**KIRKLEES COUNCIL
TOWN AND COUNTRY PLANNING ACT 1990
HIGHWAYS DEVELOPMENT MANAGEMENT**

PLANNING REF 2017/62/93197/E0/LB
CATEGORY Minor

PROPOSAL ERECTION OF DETACHED
DWELLING AND FIRST FLOOR
EXTENSION TO EXISTING
DWELLING

LOCATION 125 OXFORD ROAD
DEWSBURY
WF13 4EH

PROPOSED GROUND FLOOR PLAN
SCALE 1:50

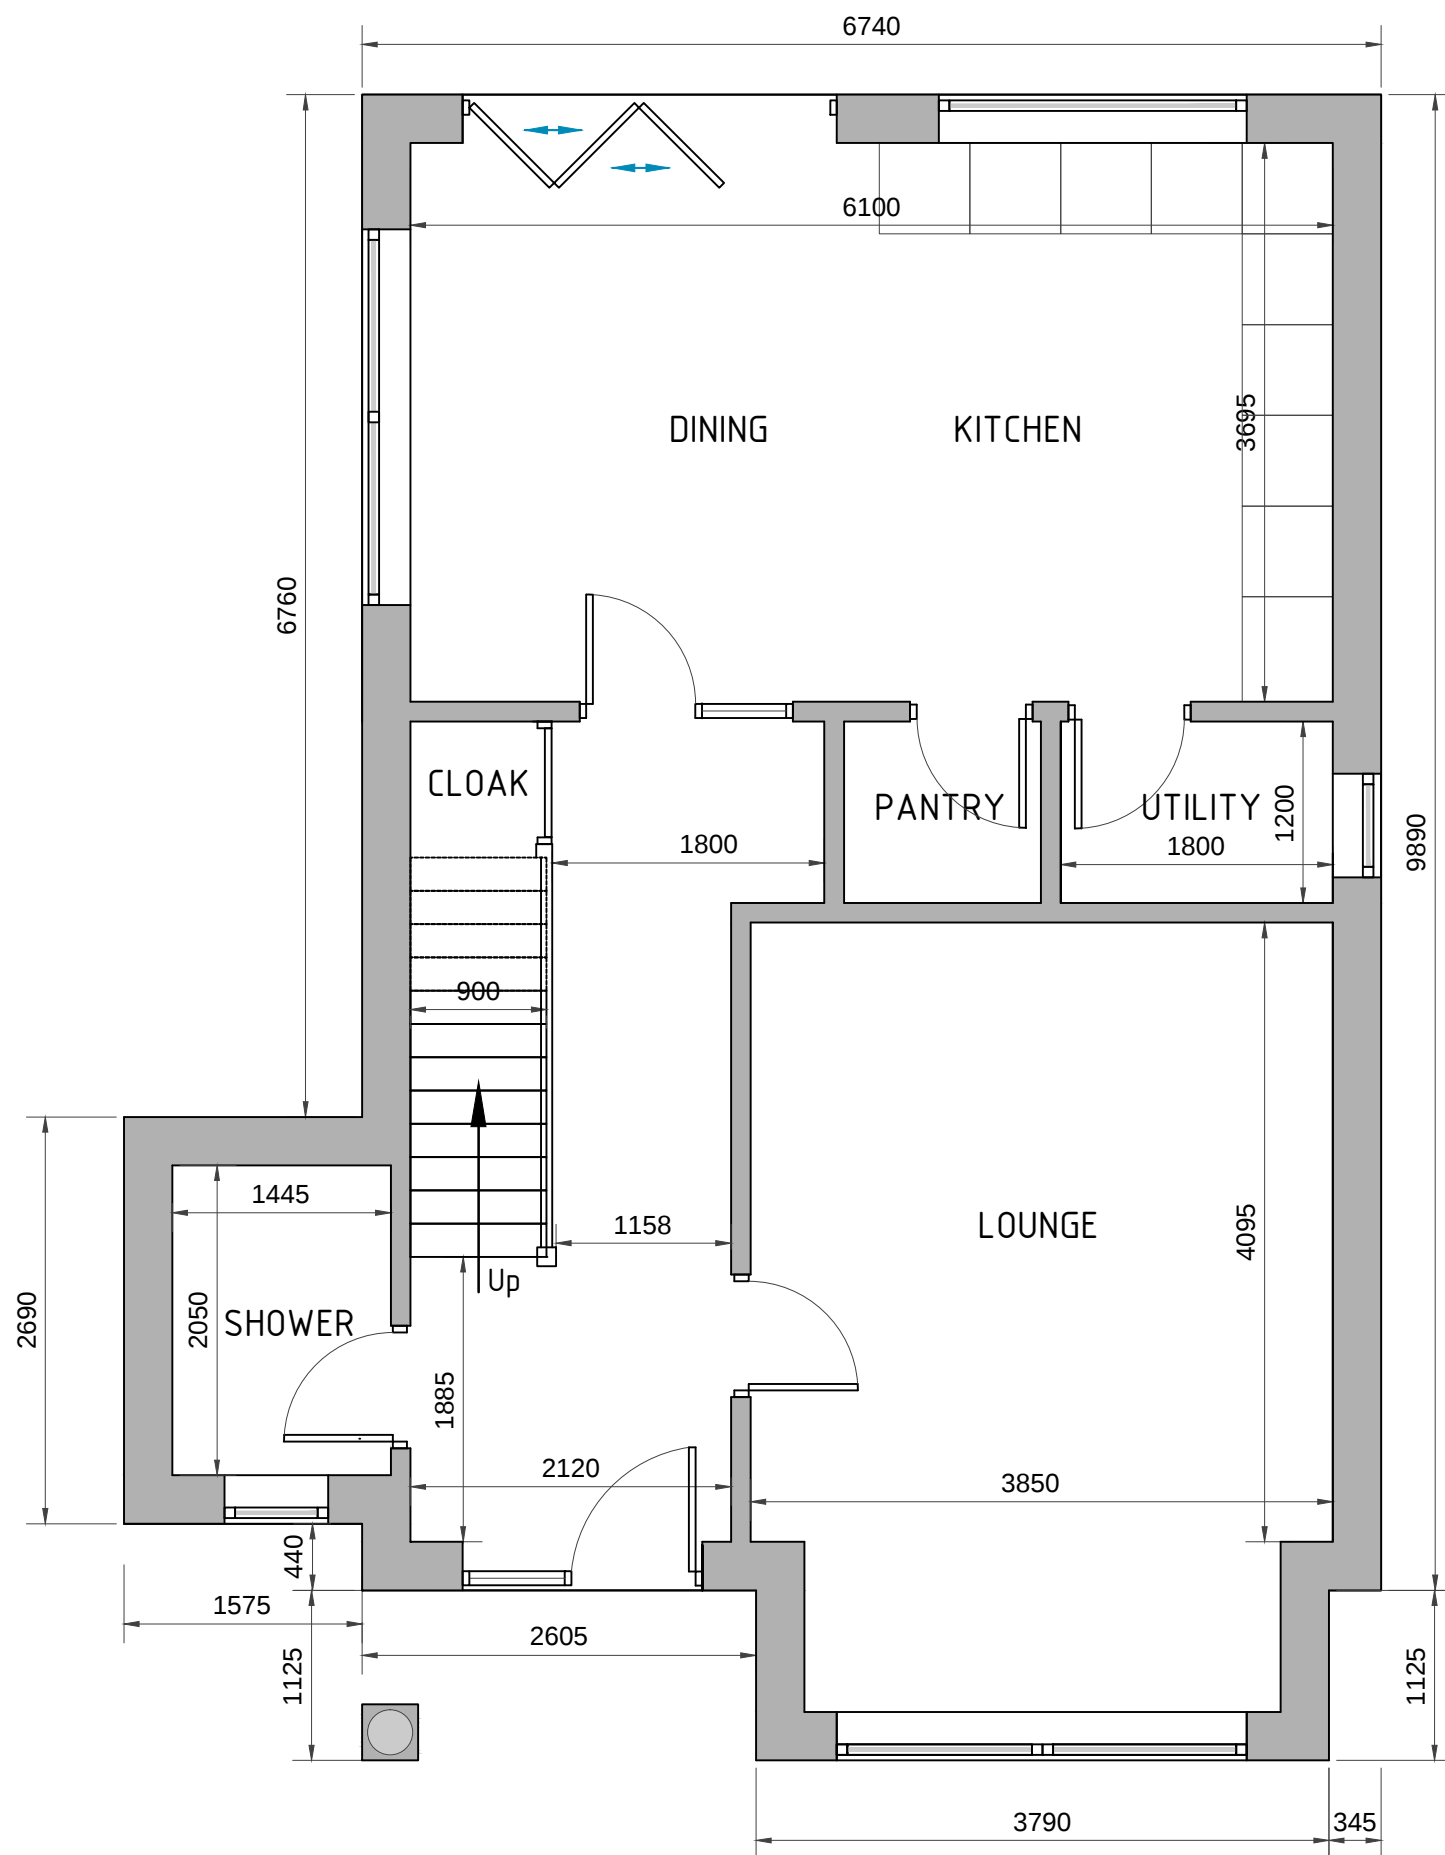
The parking provision is below the levels set out in Kirklees' UDP, which recommends three off-street parking spaces for a dwelling with four or more bedrooms and two spaces for a three-bedroomed dwelling. Highways DM would wish to see a minimum of three off-street parking spaces for the four-bedroomed dwelling. Given the land available, this should not be unachievable.

- Off-street parking provision increased to meet UDP standards and dimensioned on a plan.
 - The width of the access onto Oxford Road dimensioned on a plan.
-
